Ref: 6/2017/2062/HOUSE
Date: 07/11/2017

HISTORIC BUILDINGS AND CONSERVATION ADVICE

RE: 11 Fore Street, Hatfield, AL9 5AN

The application is for the enlargement of the current rear window, the installation of rear bi-fold doors and the replacement of doors and windows to the right hand side elevation at 11 Fore Street, Hatfield.

PROP. REAR ELEVATION (Recess)

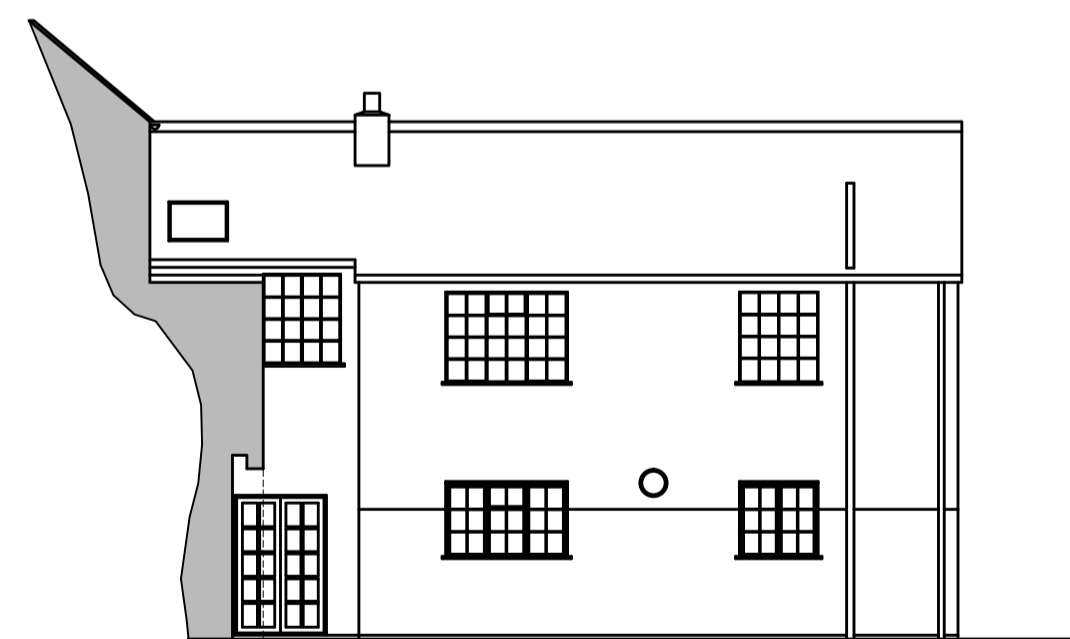
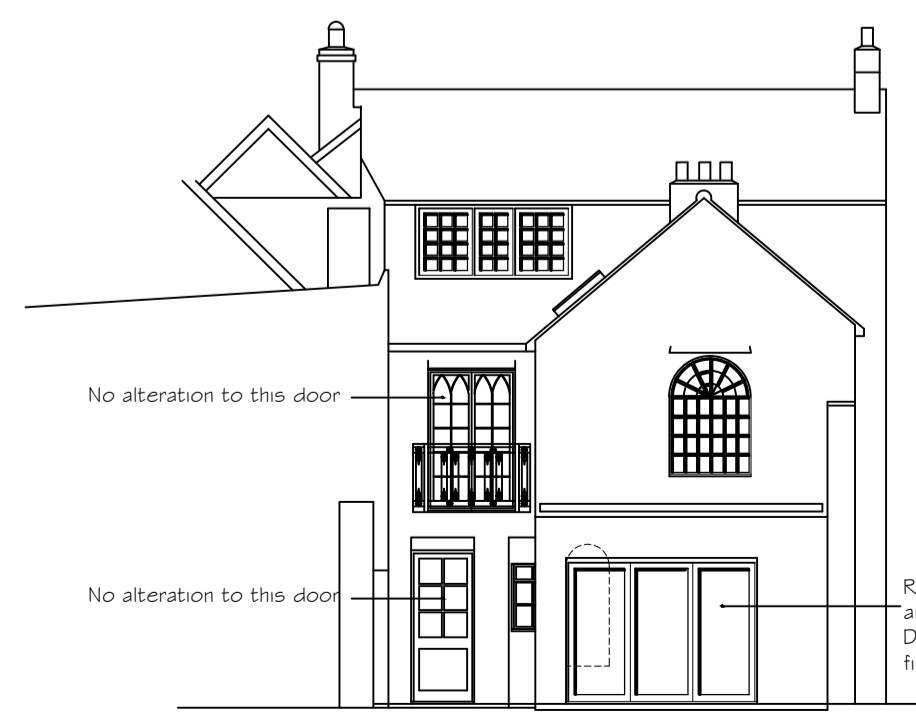
The proposed alterations to the rear elevation of the listed building comprise the removal of the existing arched window and French doors to the ground floor level and their replacement with timber bi-fold doors. It is considered that this alteration would erode the legibility and balance of the fenestration pattern to the rear elevation, which would dilute the buildings architectural interest. In addition, the proposed bi-fold doors would not be in keeping with the character of the listed building. It is therefore considered that the proposed works would cause harm to the significance of the listed building.

PROP. RIGHT HAND SIDE ELEVATION (Part)

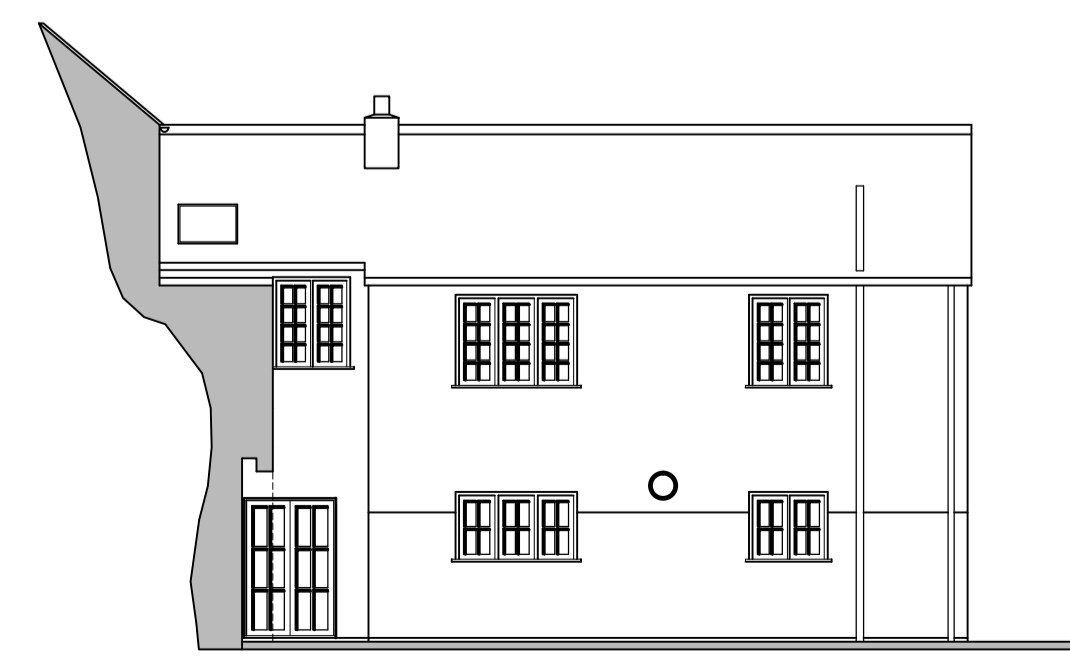
It is also proposed to replace the existing window to the second floor of the rear elevation and the existing windows and door to the west elevation of the rear projection with timber double glazed windows. There is no objection in principle to the replacement of the existing windows and door, however, it is considered that the design and detailing of the proposed windows would considerably alter the appearance of these elevations due to the change to the glazing bars, and therefore should be reconsidered to be in keeping with the character of the listed building.
